**Re: 4001 West Mercer Short Plat
SUB21-002**

Please consider this as a written response to the City of Mercer Island first review comments dated September 14, 2021.

RE: Request for Information #1 for File No. SUB21-002 – Angiuli Pacific Res Trust Short Subdivision 4001 West Mercer Way, Mercer Island, WA 98040; King County Tax Parcel # 362350-0365

**4001 WEST MERCER WAY SHORT PLAT
SHORT PLAT MAP**

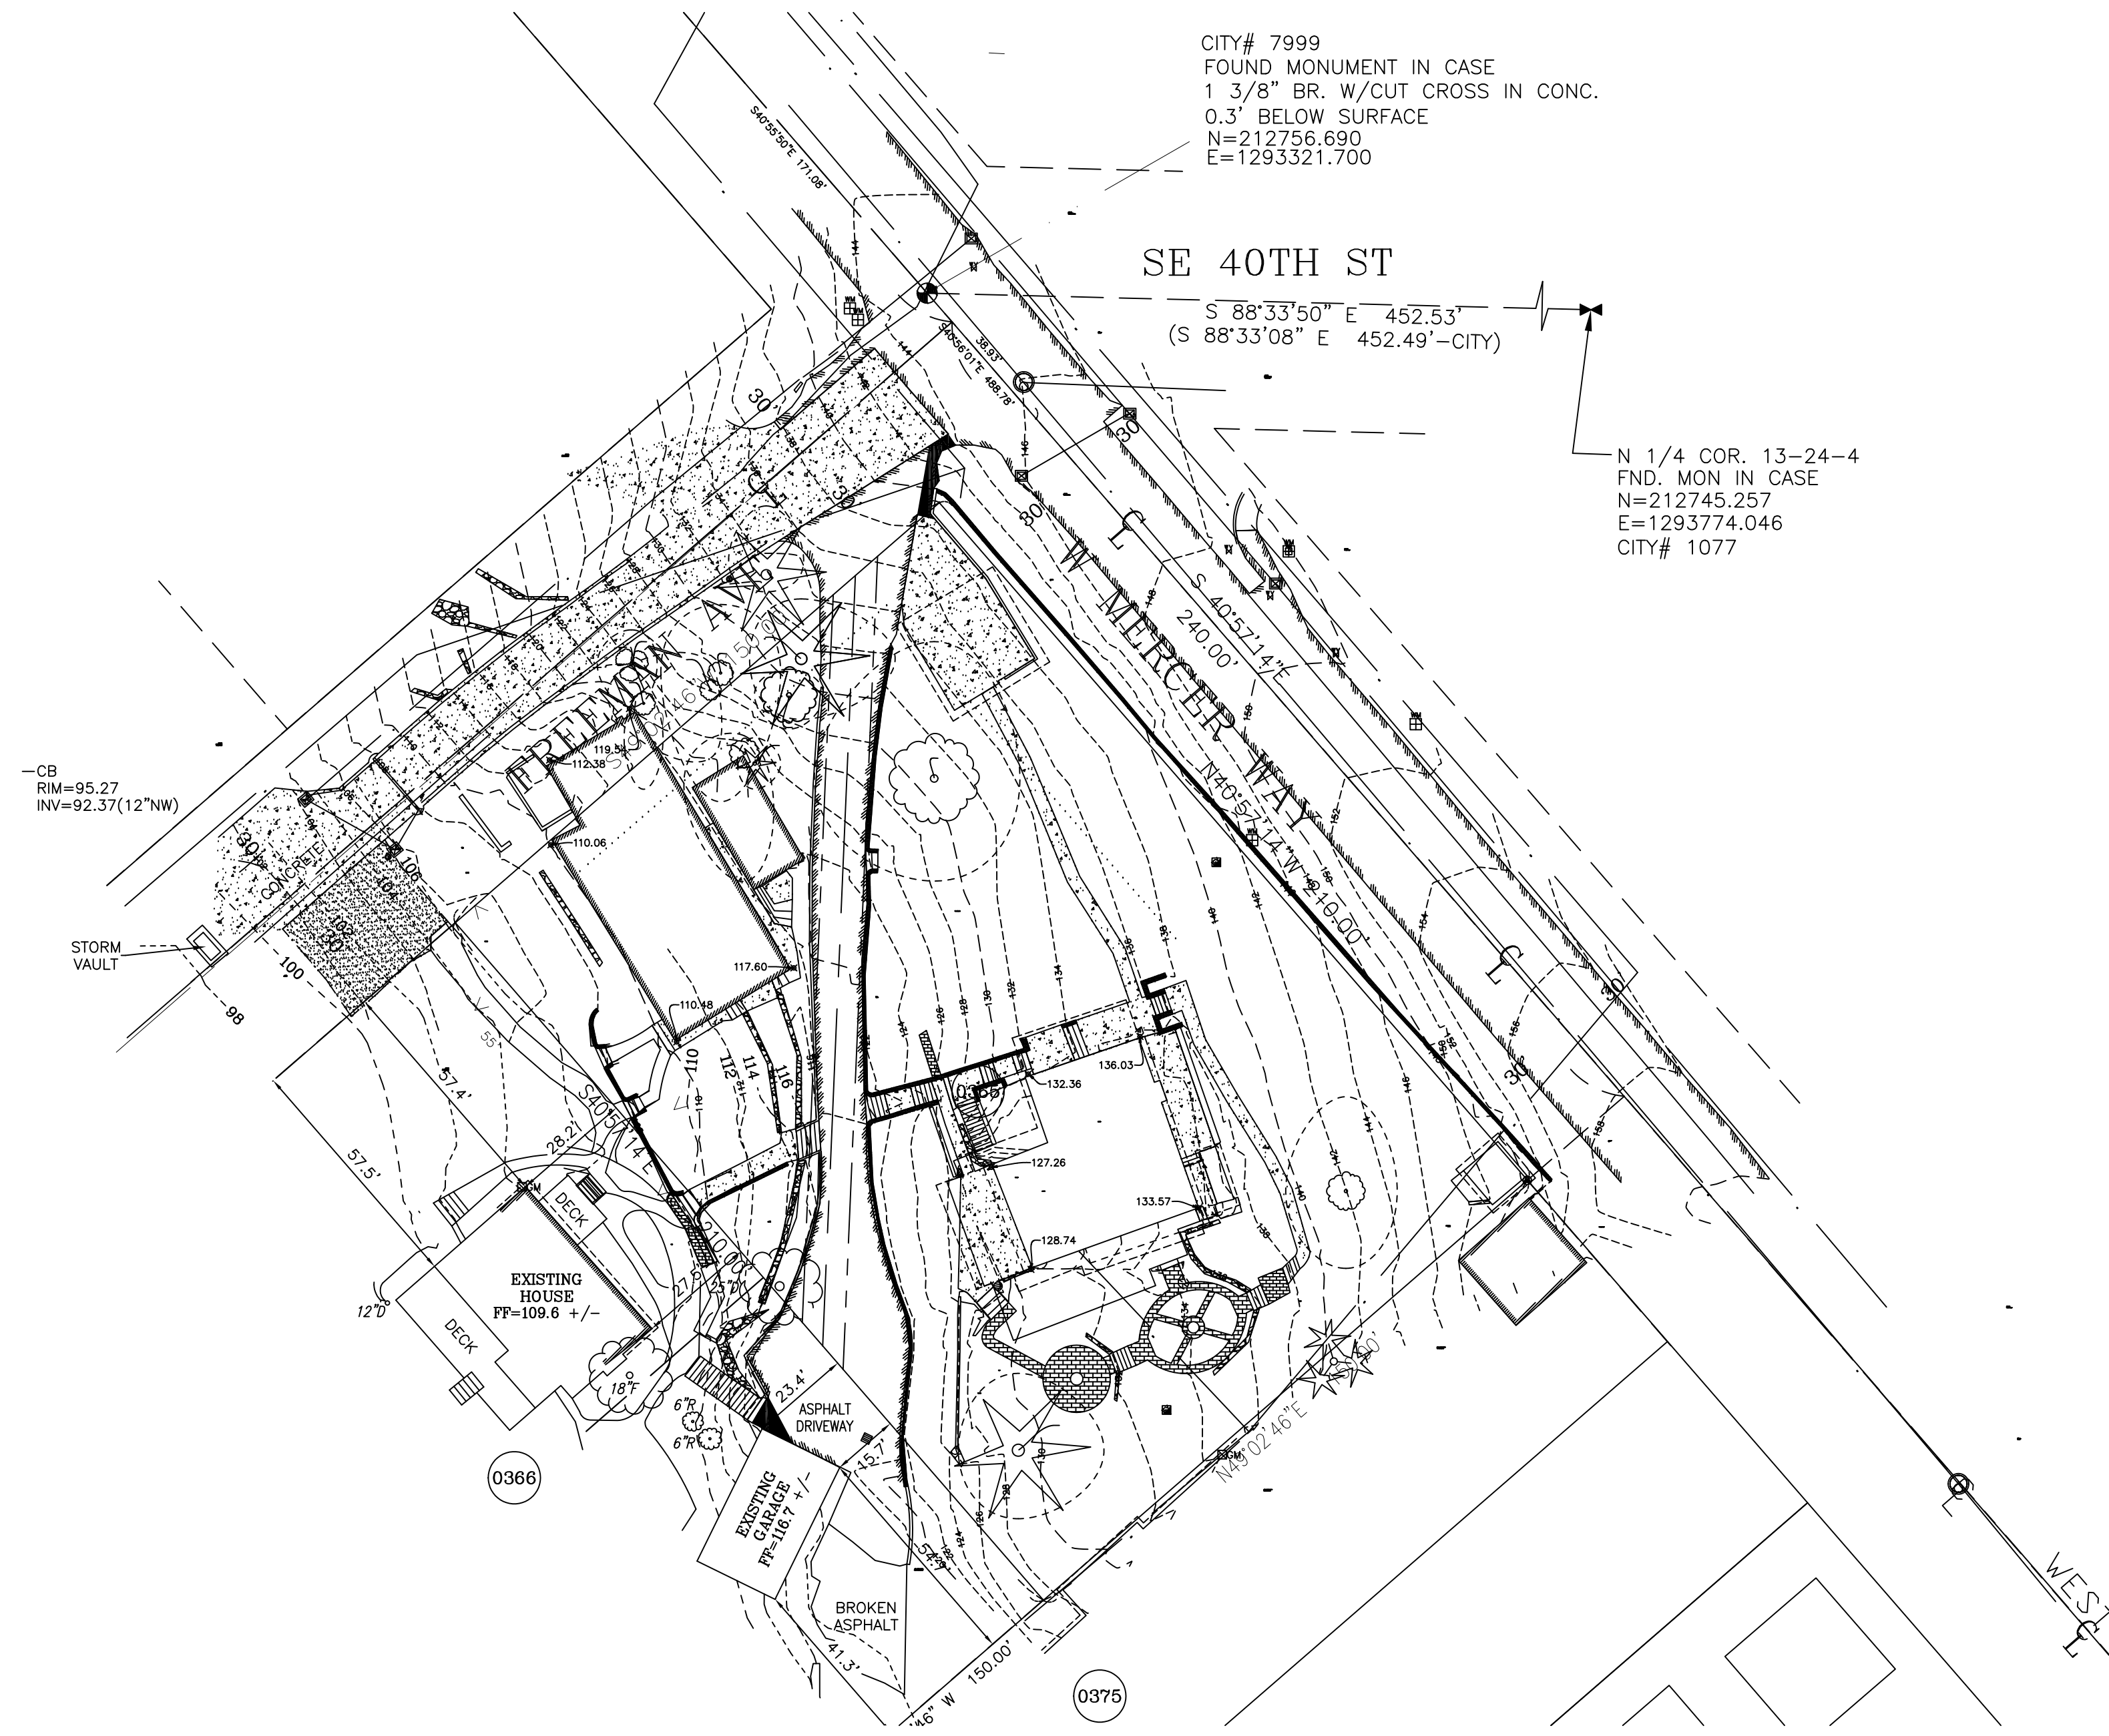
- a. Need surveyor's signature. **Provided on Sheet 1 of 4 of Short Plat Map**
- b. The boundary survey needs to show the existing 10-foot access easement and note the recording number (#7205310117). **Shown on Sheet 3 of 4 of Short Plat Map**

6. Access easement:
- a. Clearly list existing easements to remain and be extinguished, as well as proposed easements. **Sheet 3 of 4 of the Short Plat Map calls out easements to be added to project**

4001 WEST MERCER WAY SHORT PLAT
TOPOGRAPHIC MAP

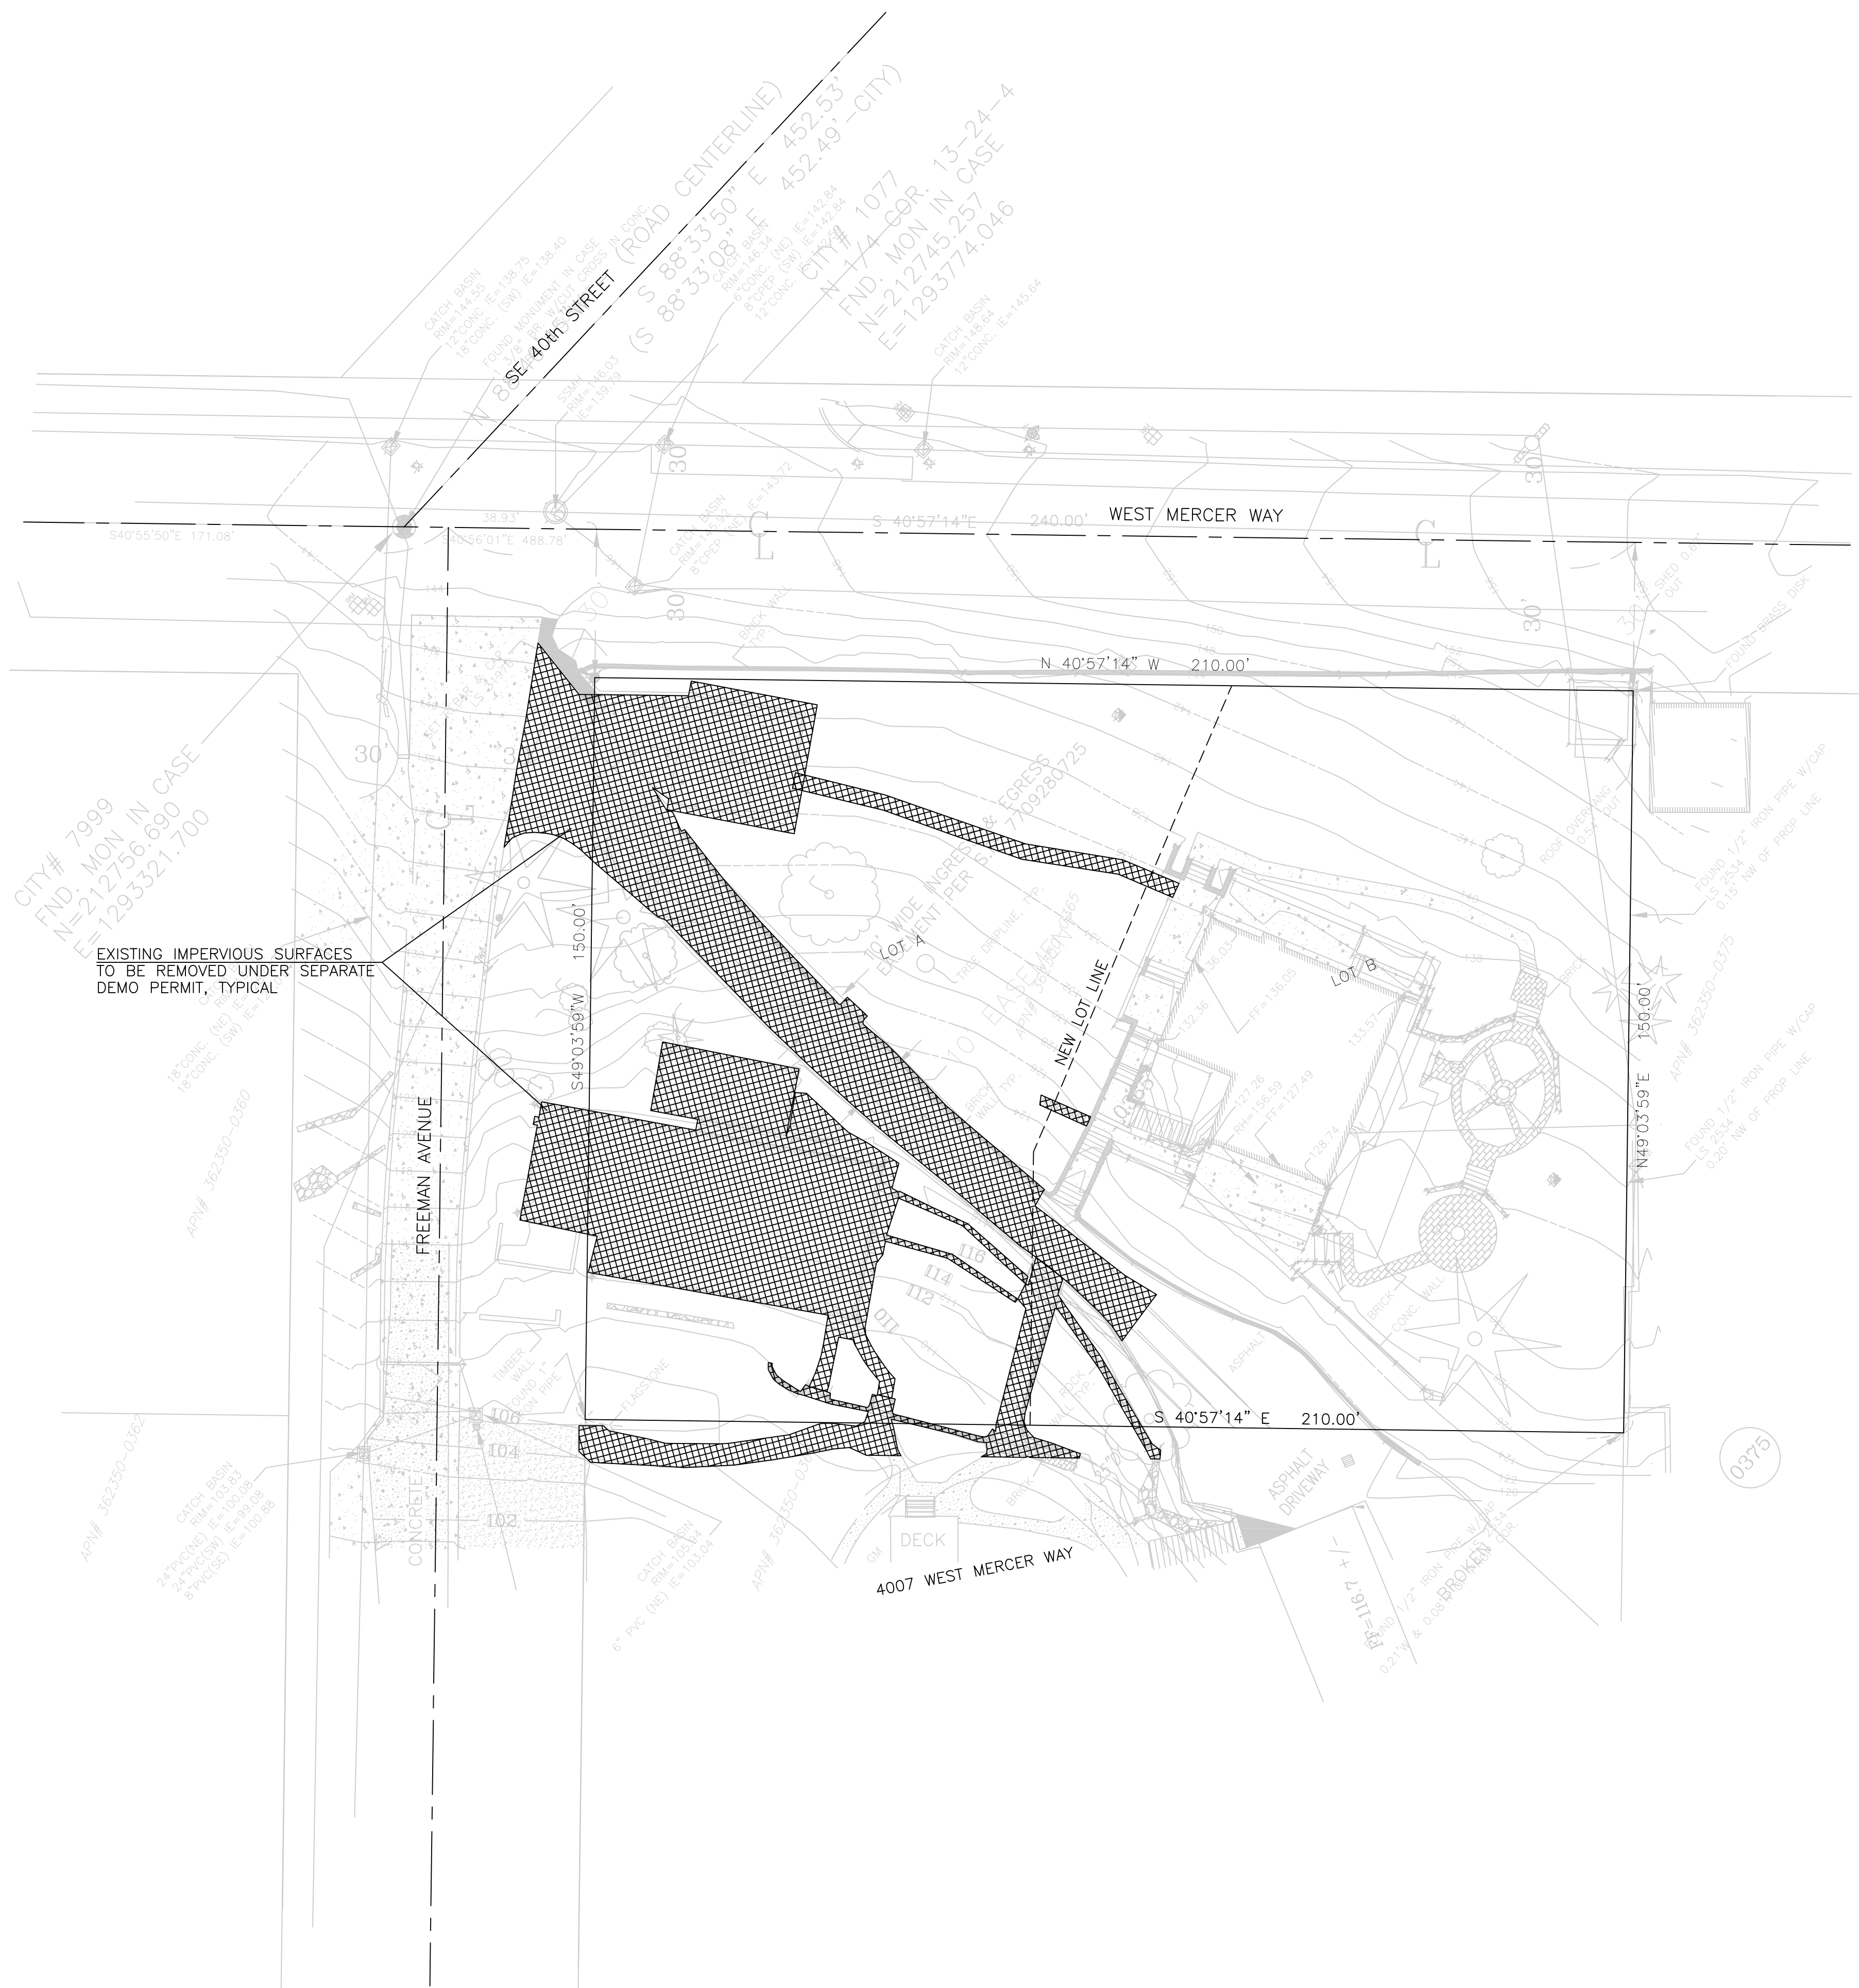
- c. Please include the land use file number, "SUB21-002", on the plan set. **All Plan sheets within Development Plan Set include file number**
- d. Topographic map: for any existing buildings, the map shall show the finished floor elevations of each floor of the building. **The information can be found on the Short Plat Map sheet 4 of 4**
